Appeal Decision

Appeal Ref: APP/R5510/D/23/3325300

49 Queens Walk, Ruislip, Hillingdon, HA4 0LX

- The appeal is made under section 78 of the Town and Country Planning Act 1990 against a refusal to grant planning permission.
- The appeal is made by Mr K Singh against the decision of the Council of the London Borough of Hillingdon.
- The application Ref 1055/APP/2023/845, dated 16 March 2023, was refused by notice dated 16 May 2023.
- The development proposed is a two storey rear extension with accommodation in roof.

DRAWING TITLE:
PROPOSED ELEVATIONS

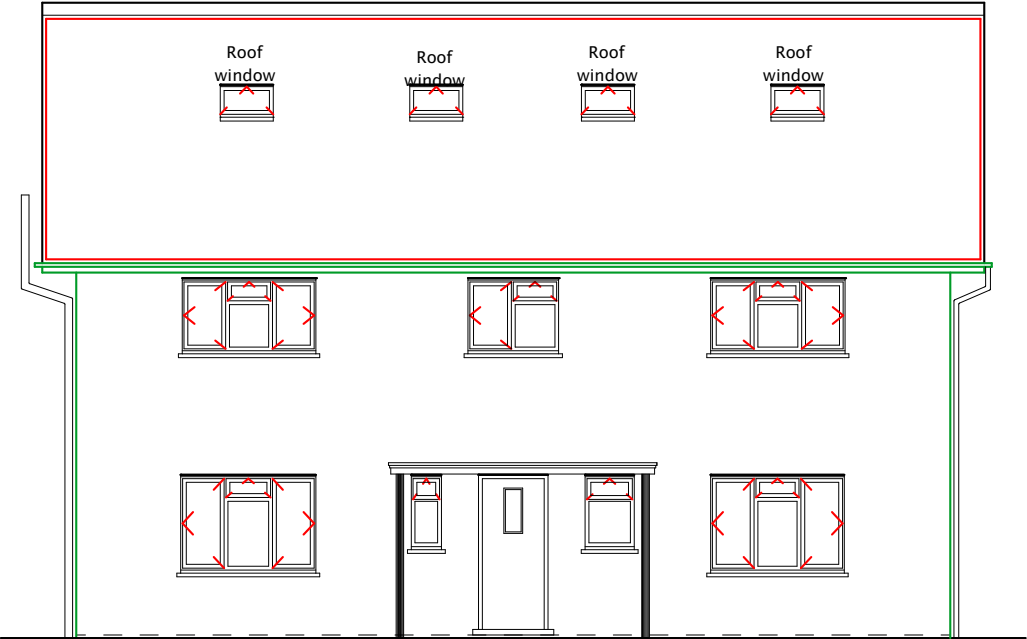
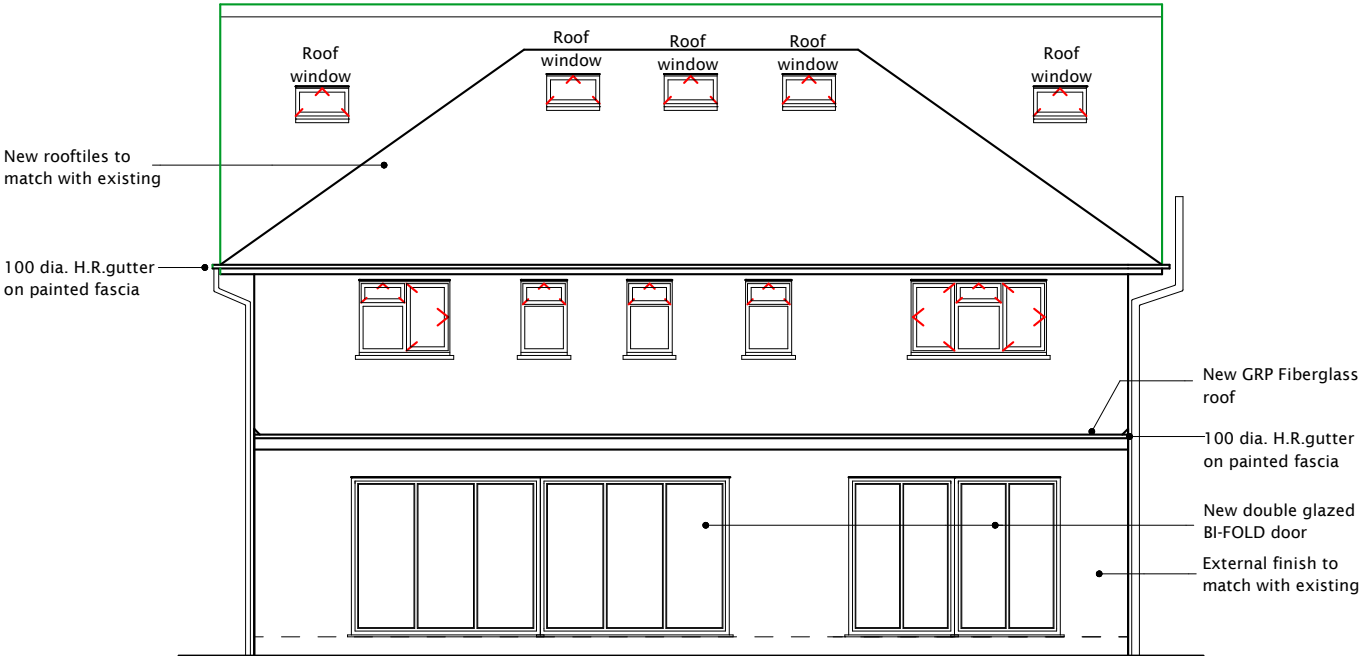
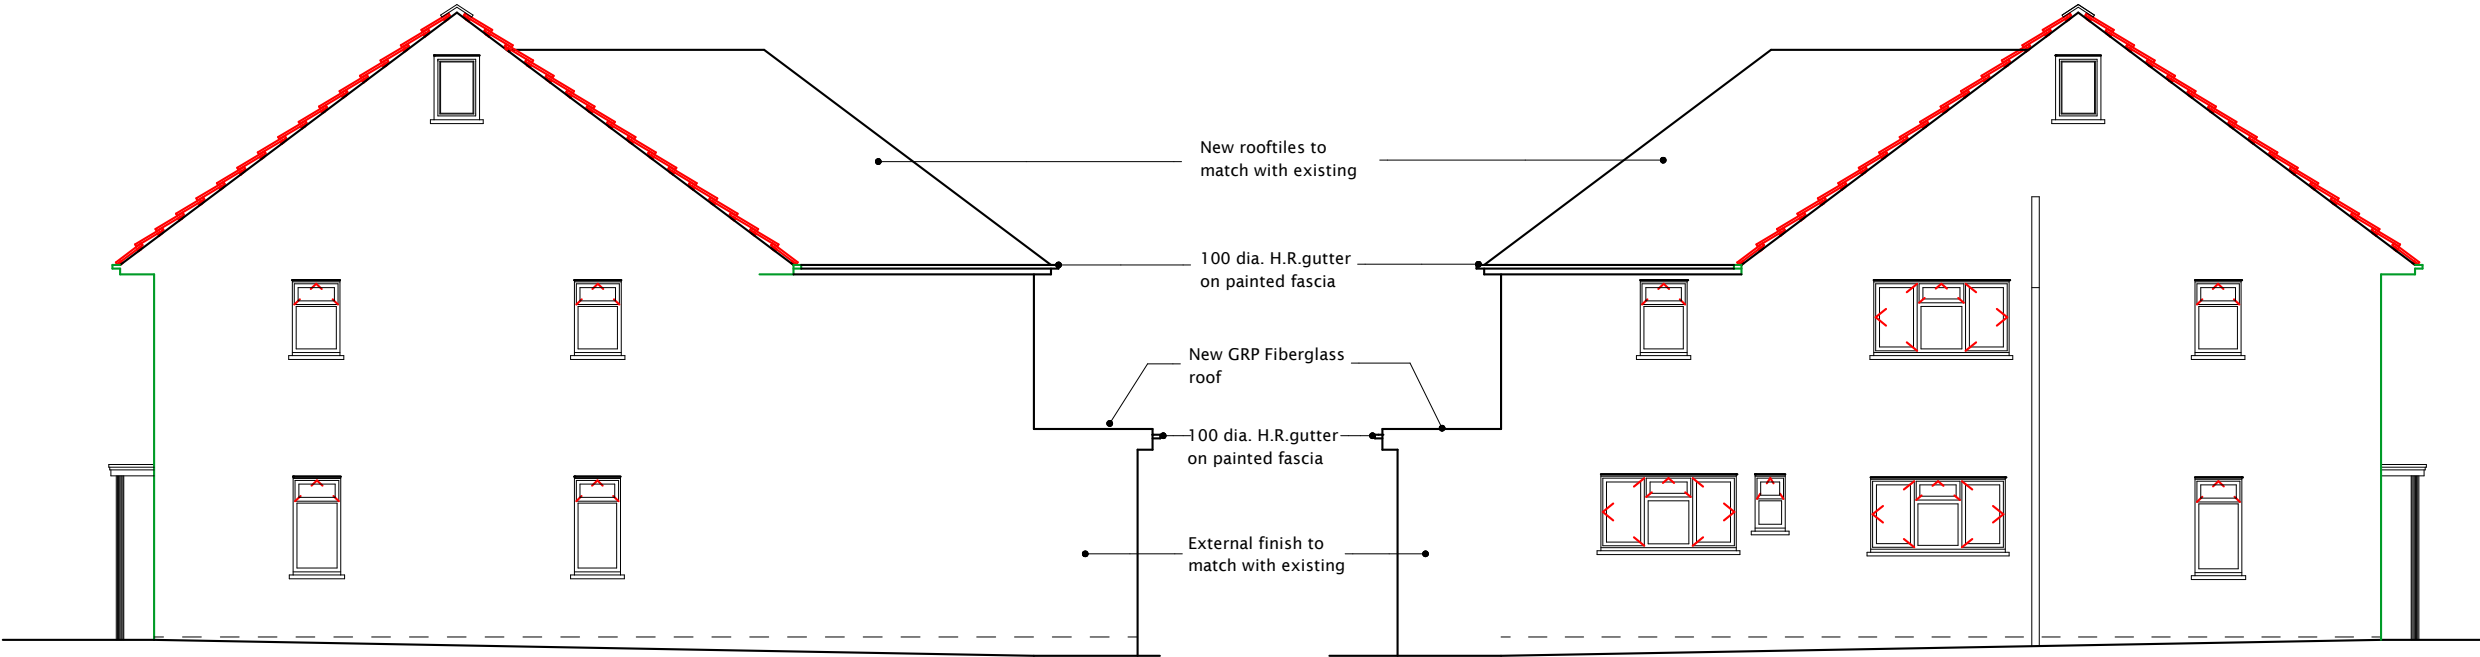
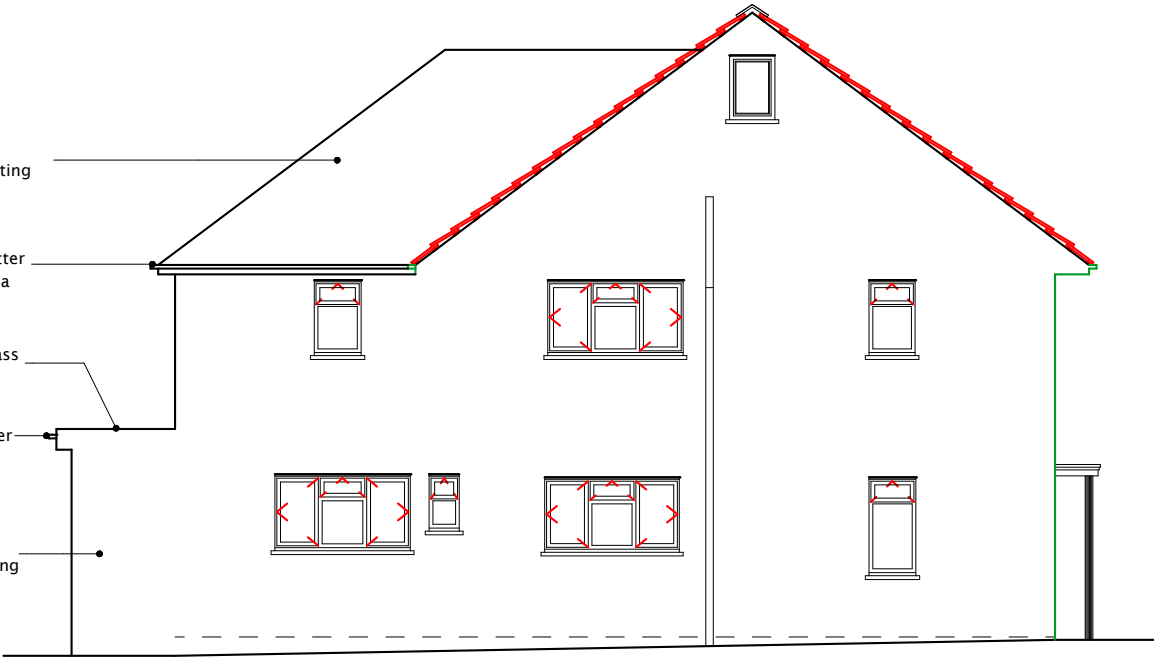
11. The proposed development would extend the already extended dwelling to the rear, at ground floor and first floor level and would add a large crown roof to the rear of the recently converted gable roof.

12. The overall effect of the proposal would be to add such significant scale and volume as to overwhelm what is already a prominent dwelling of dominant appearance.

13. It would I find, result in a combined roof and rear extension that would fail to appear subordinate to the host property and which would draw attention to itself as an overly large and bulky addition. Further, the proposed crown roof would visually jar with the host property, appearing as an unsympathetic addition.

14. In addition, the harm arising from the above would be exacerbated as a result of the proposal appearing incongruous in its surroundings, where no such roof form as that proposed exists.
